MMO Reference: DCO/2022/00007  
Planning Inspectorate Reference: EN010125  
Identification Number: 20050160

14 October 2025

**Planning Act 2008, RWE Renewables UK Dogger Bank South (West) Ltd and RWE Renewables UK Dogger Bank South (East) Ltd Proposed Dogger Bank South Offshore Wind Farms Order**

**Post Examination – Additional Information**

**'Without Prejudice' Herring Spawning Plan
(Revision 2)**

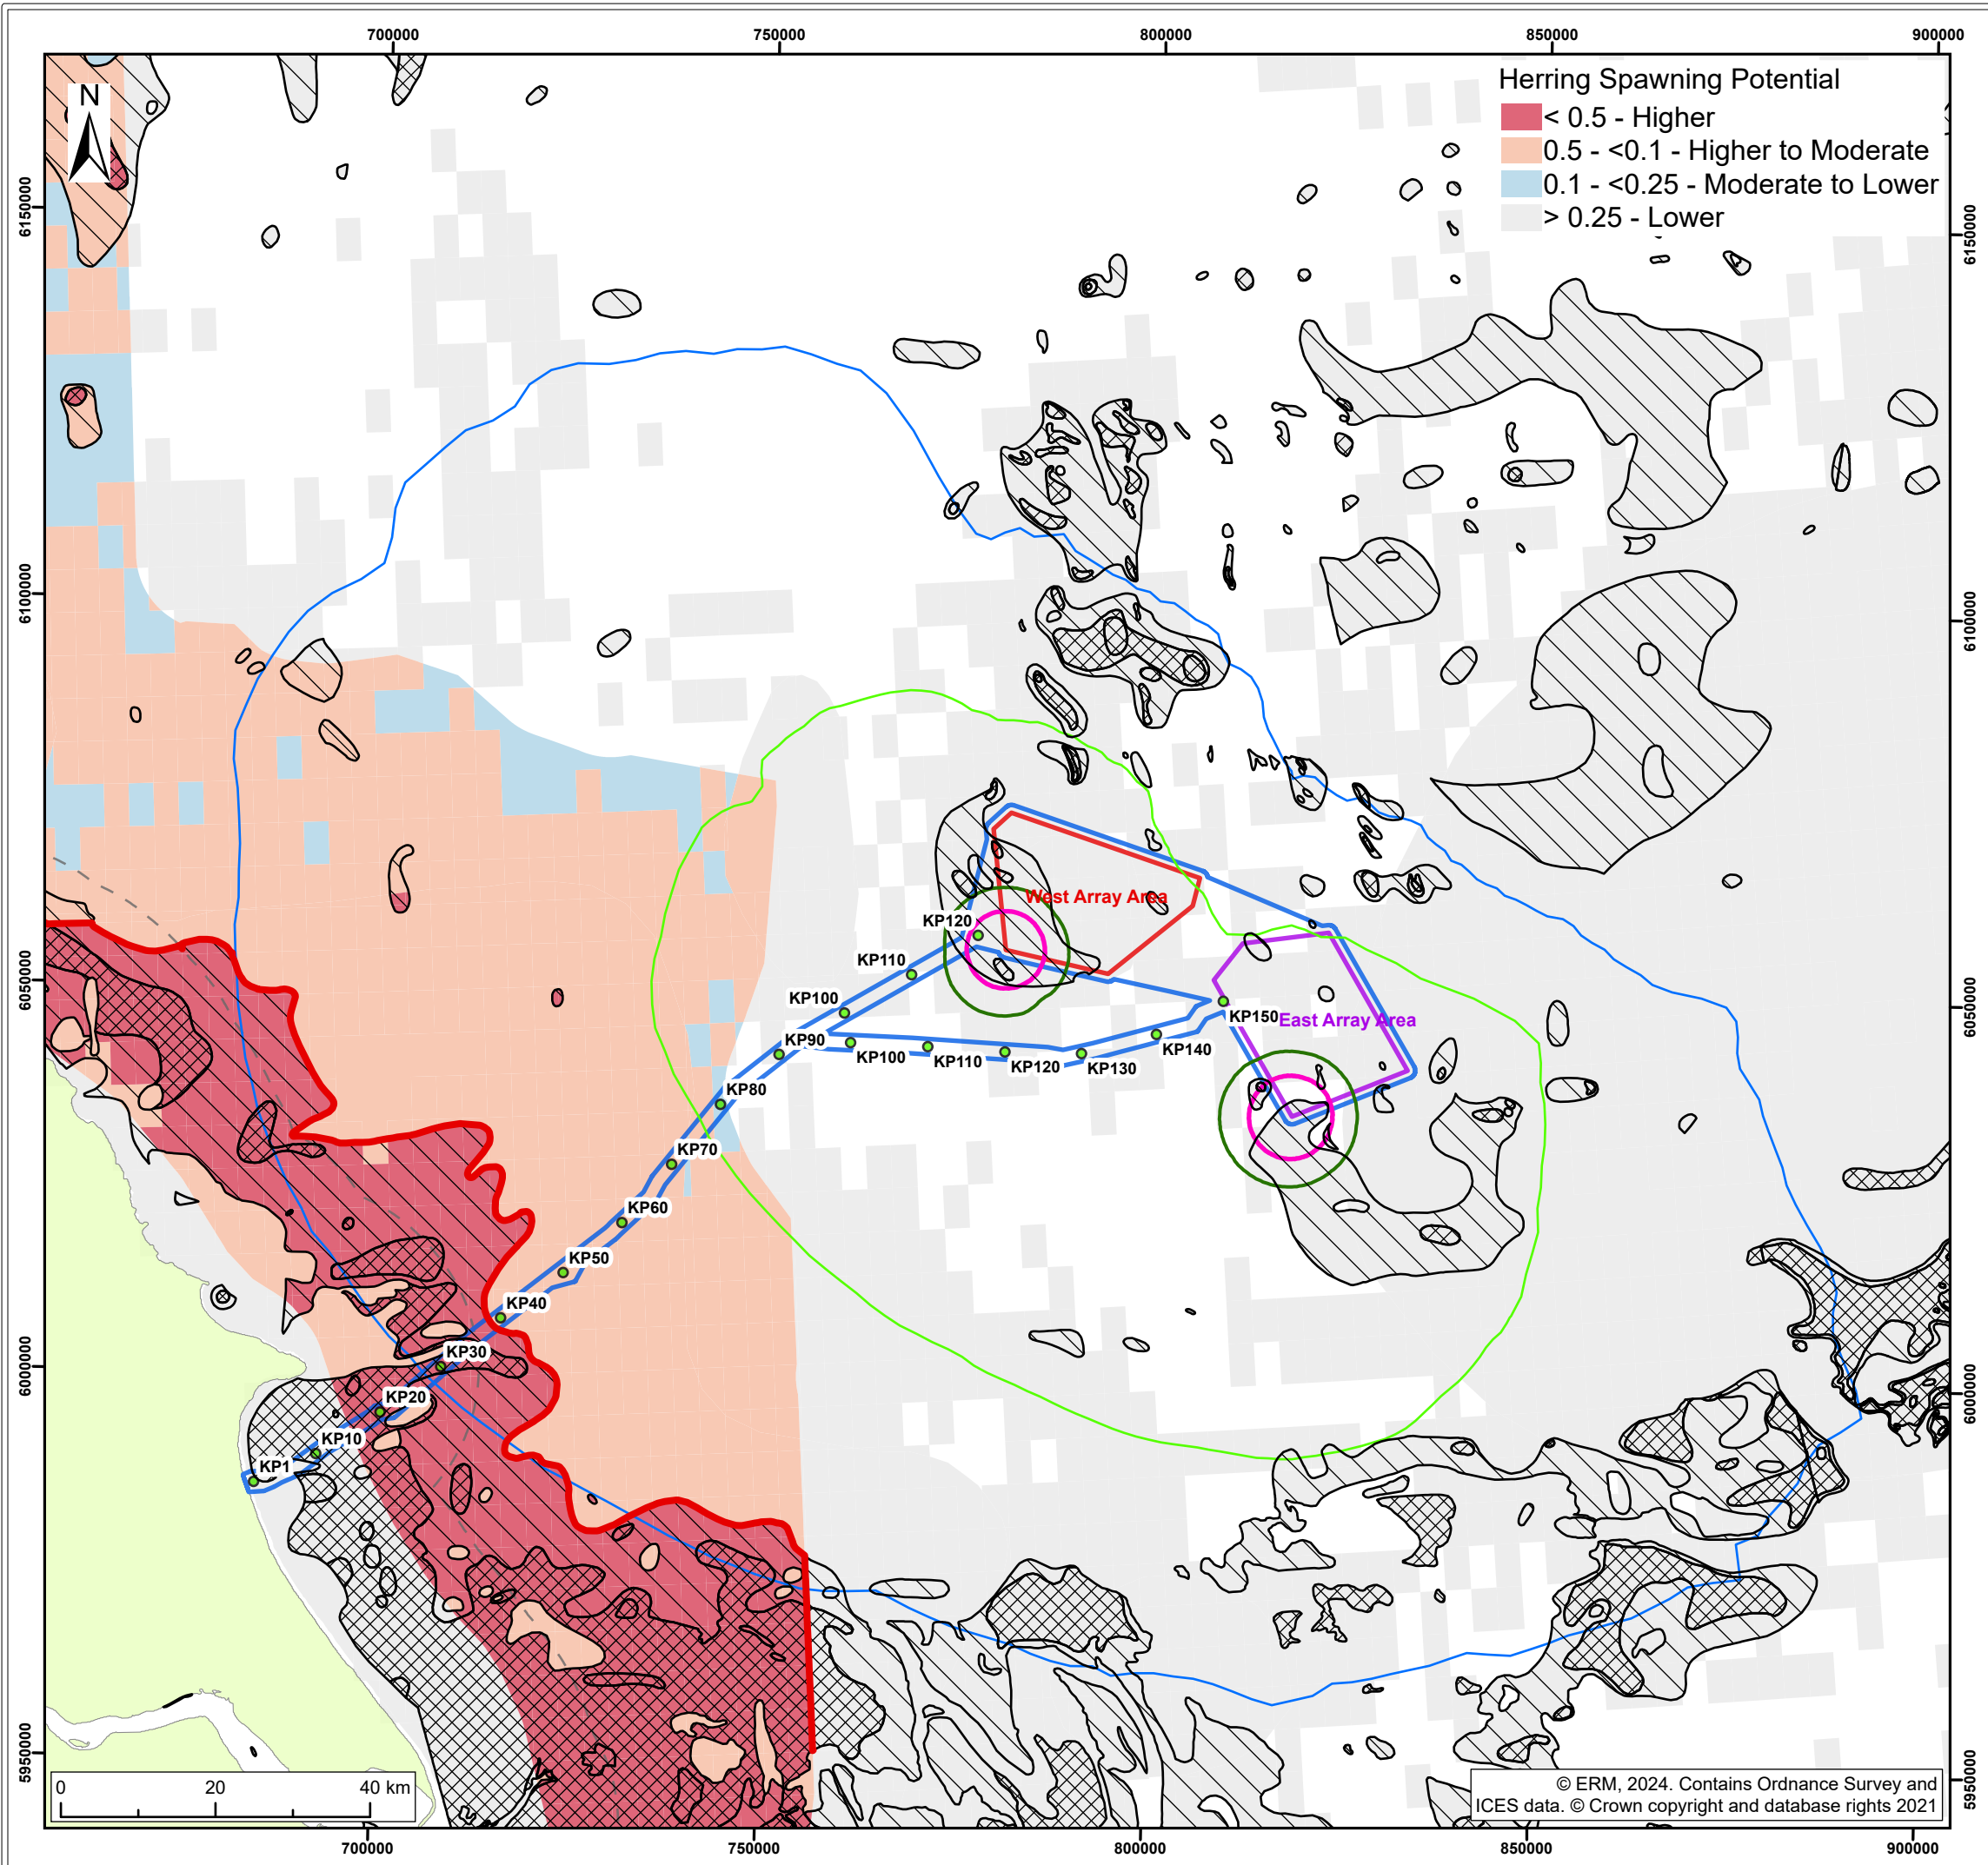
- 5.1 During the September meeting the Applicants proposed that the Herring Spawning Noise Restriction Boundary should remain drawn at the edge of the spawning ground such that the 135dB contour does not overlap with potential spawning habitat. This would result in >38km 'migration corridor' between the coastline and the extent of the 135dB contour that encompasses the entire spawning ground.

- 6.1 The MMO has reviewed "The Applicant's and the MMO's Post-Examination Joint Statement on the Without Prejudice Herring Noise Restriction" which is dated October 2025 and have agreed the below condition as well as signed the joint position statement.

*“Herring Spawning Noise Restriction Boundary” means the boundary indicated by the red line on the herring spawning area plan, with the restricted area being the area shoreward of this boundary*
